KITTITAS COUNTY COMMUNITY DEVELOPMENT SERVICES

RE: Rosenberry Boundary Line Adjustment (BL-22-00017) – Transmittal of Comments and Request for Additional Information

Parcel# 959264	Parcel# 144835	Parcel# 634835
Parcel# 081936	Parcel# 071936	Parcel# 154835

- L1 N 13°15'51" E, 40.68'
- L2 N 74°33'25" E, 12.38'
- L3 N 38°53'30" E, 27.70'
- L4 N 18°04'14" E, 30.22'
- L5 N 14°36'50" W, 61.70'
- L6 N 01°09'02" W, 14.60'
- L7 N 22°02'24" E, 75.00'
- L8 S 75°38'31" E, 8.18'
- L9 S 61°41'00" E, 14.09'
- L10 N 61°03'51" E, 27.30'

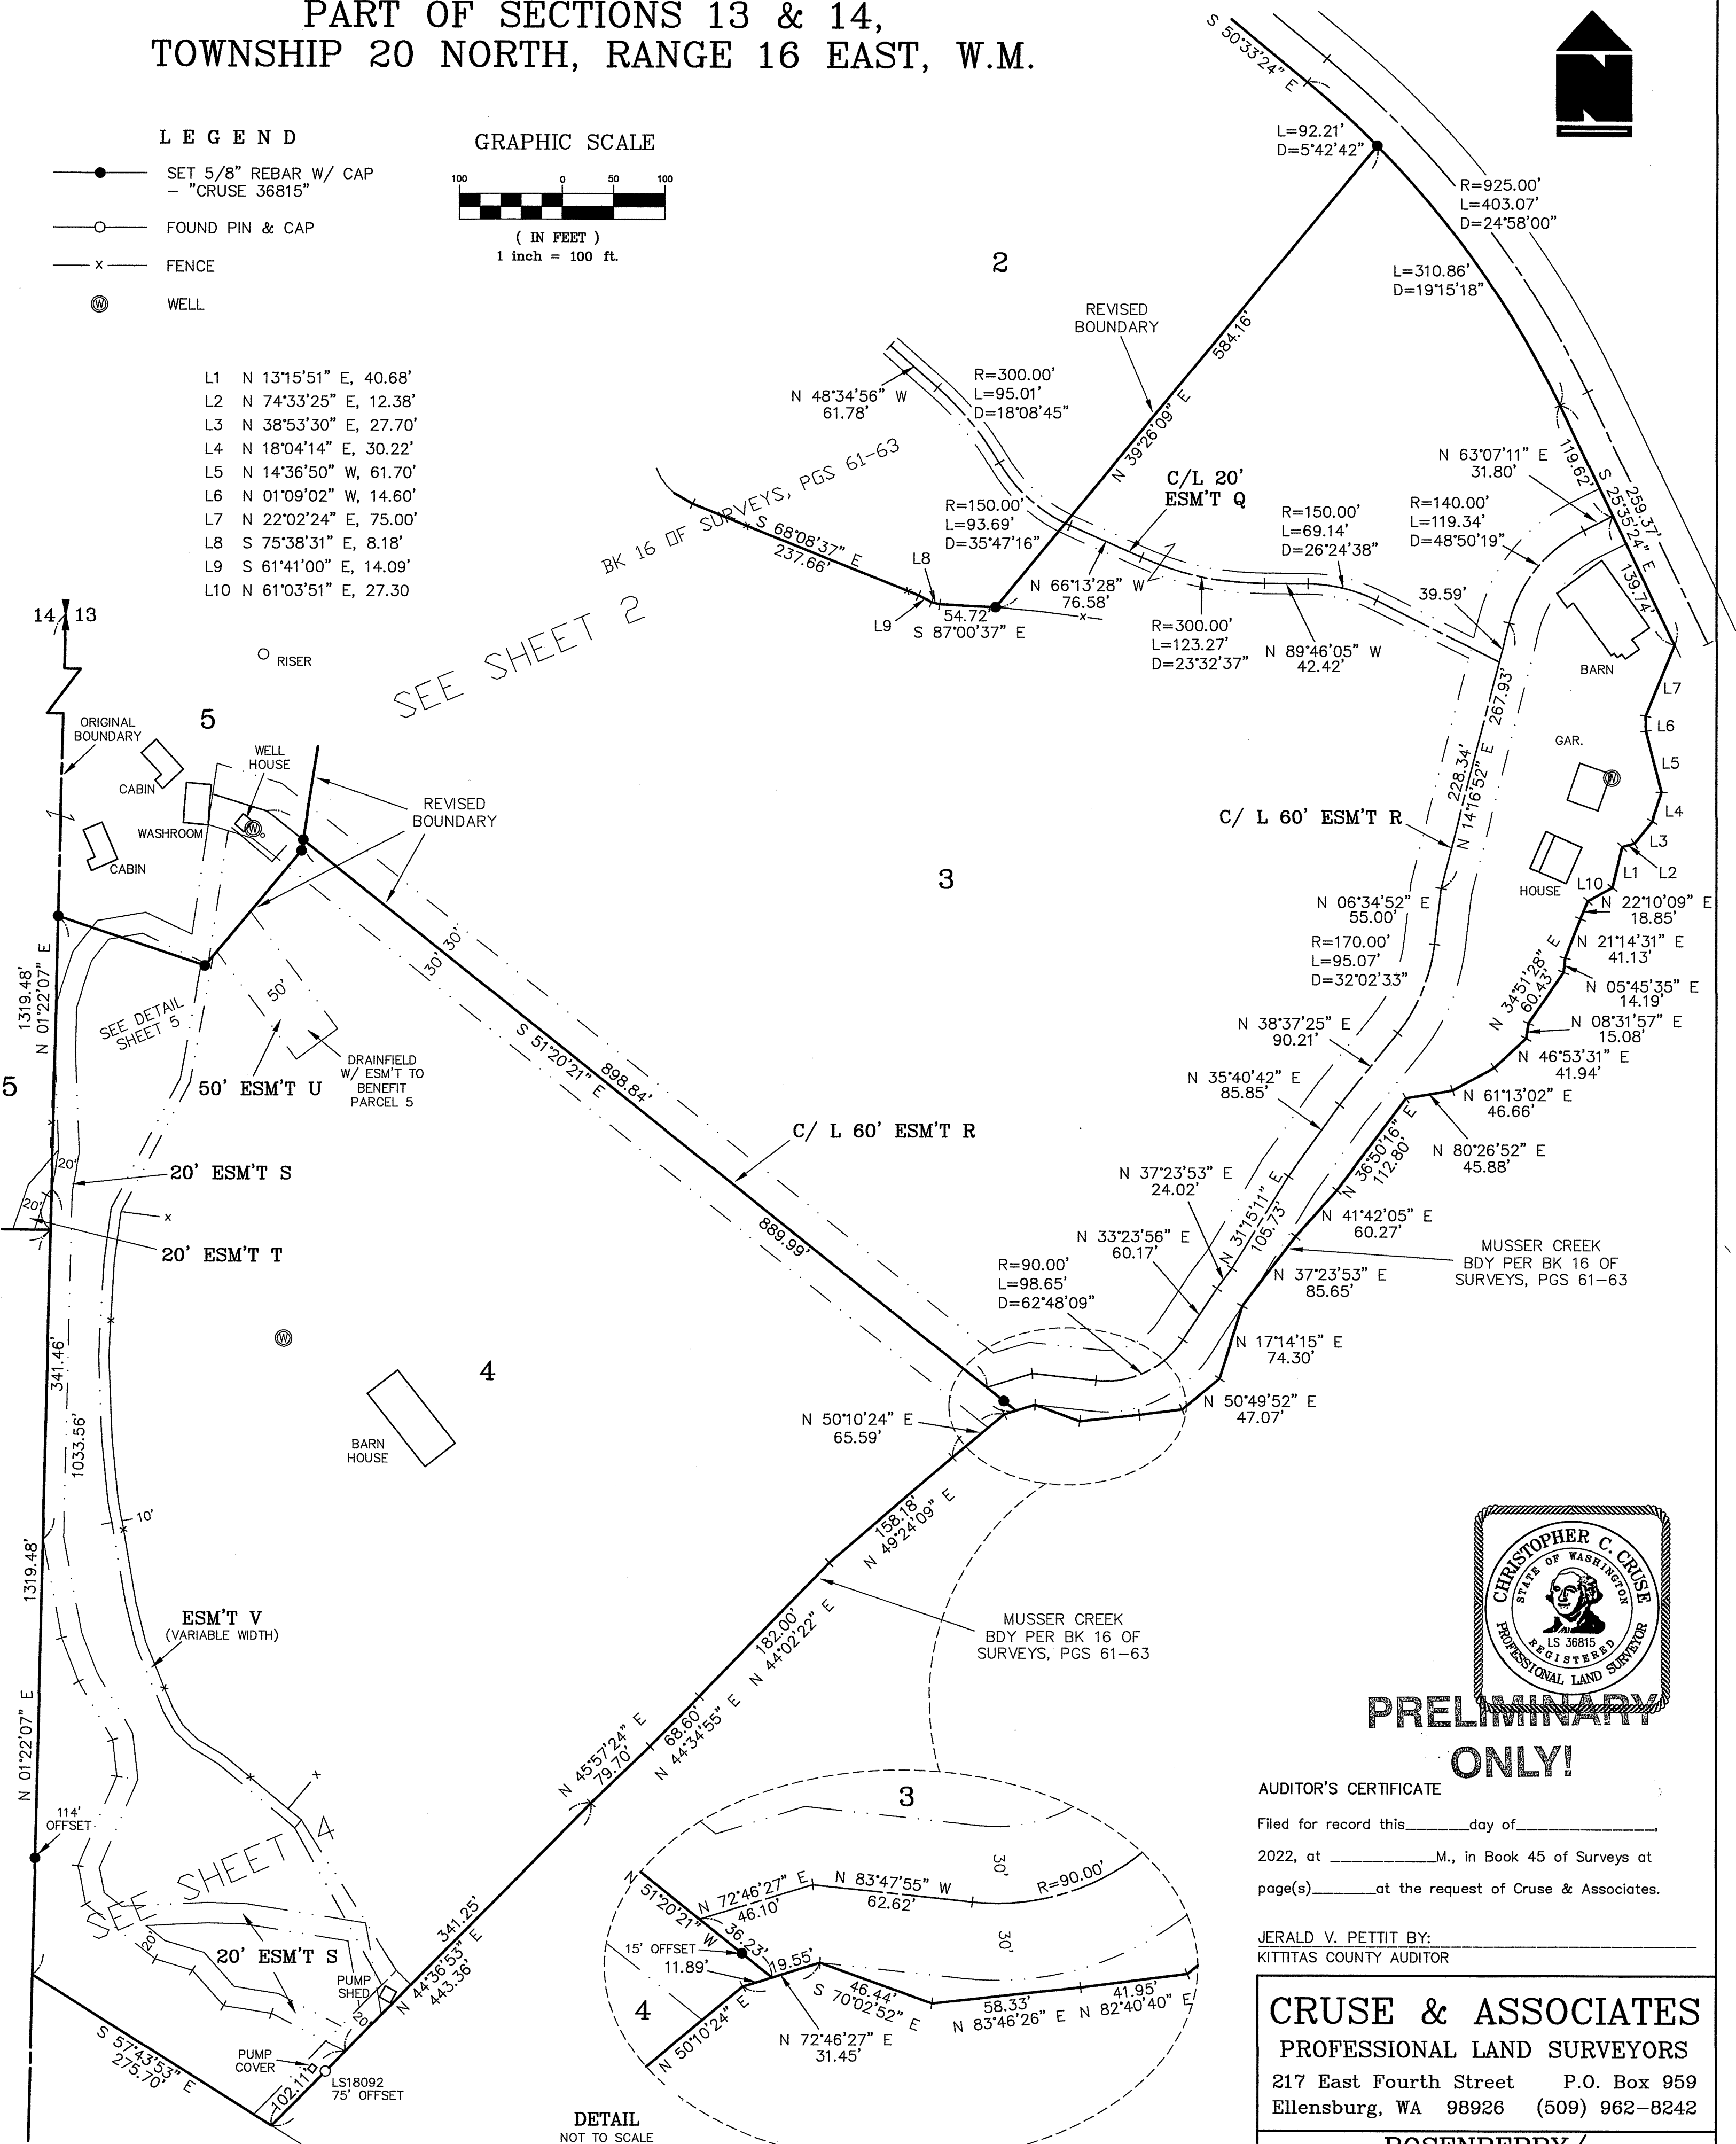
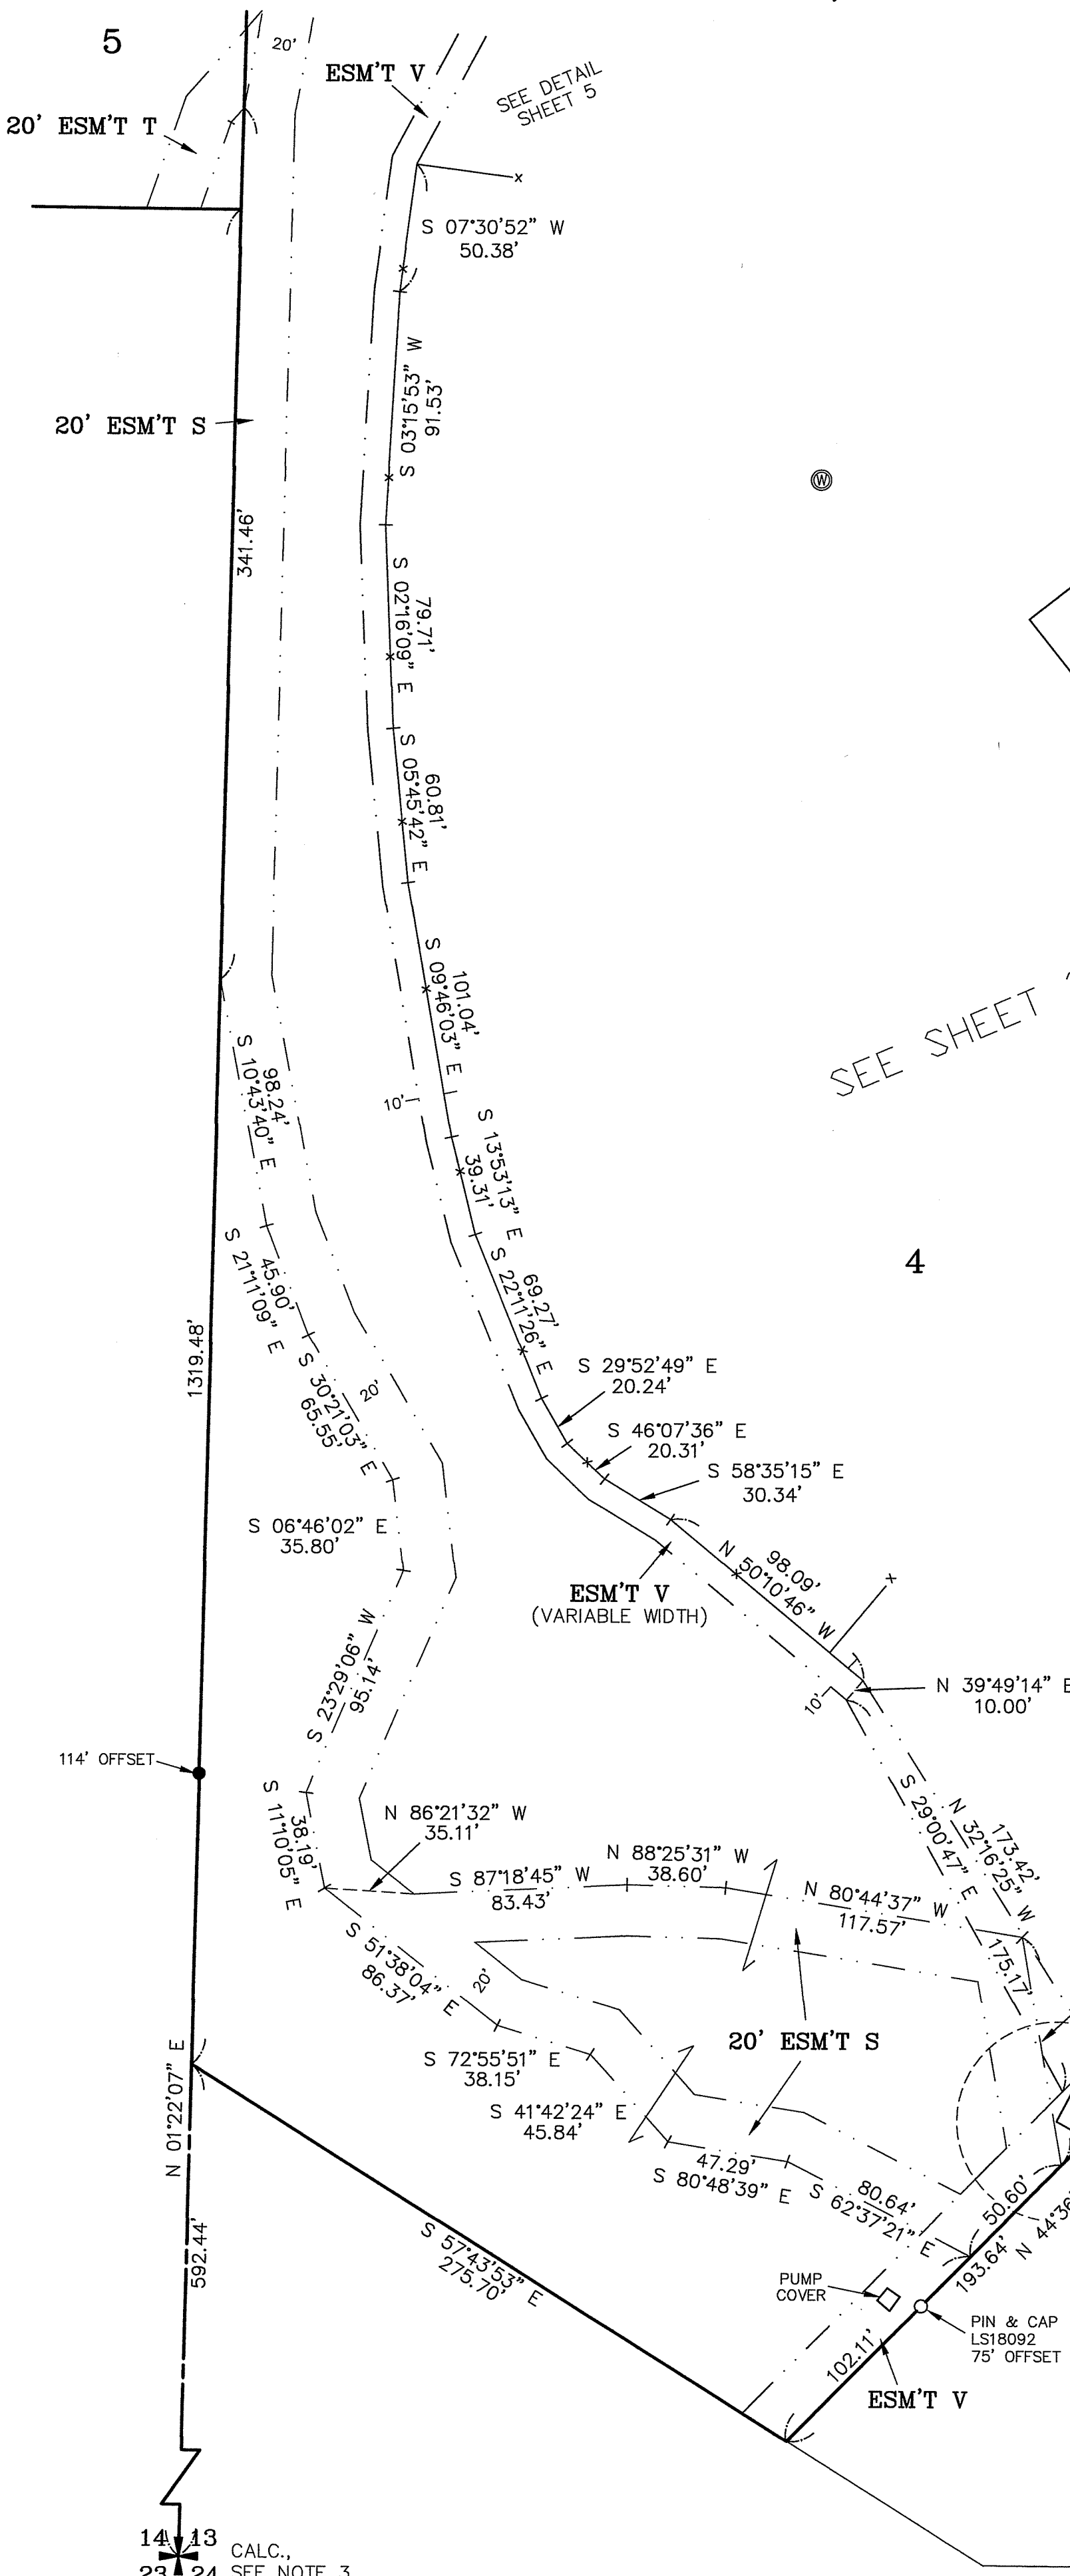
1. Provide the distance from the existing well to the property line on the new proposed property lines of parcel 5
2. Provide the distance from the septic tanks and drainfield from the proposed property line between parcel 4 and parcel 5.
3. A **preliminary survey** displaying legal descriptions, the new acreage and lot dimensions of each parcel must be submitted to our office for preliminary review (see Public Works' comments for requirement details).
4. Full year's taxes need to be paid for all tax parcel numbers per requirement of the Kittitas County Treasurer's Office. Please contact this office when this is accomplished as the Treasurer's office will not be aware of your pending application. No paperwork or receipt is required; just a phone call or an email will suffice.
5. Please refer to the enclosed comments from Kittitas County Public Works for further requirements.
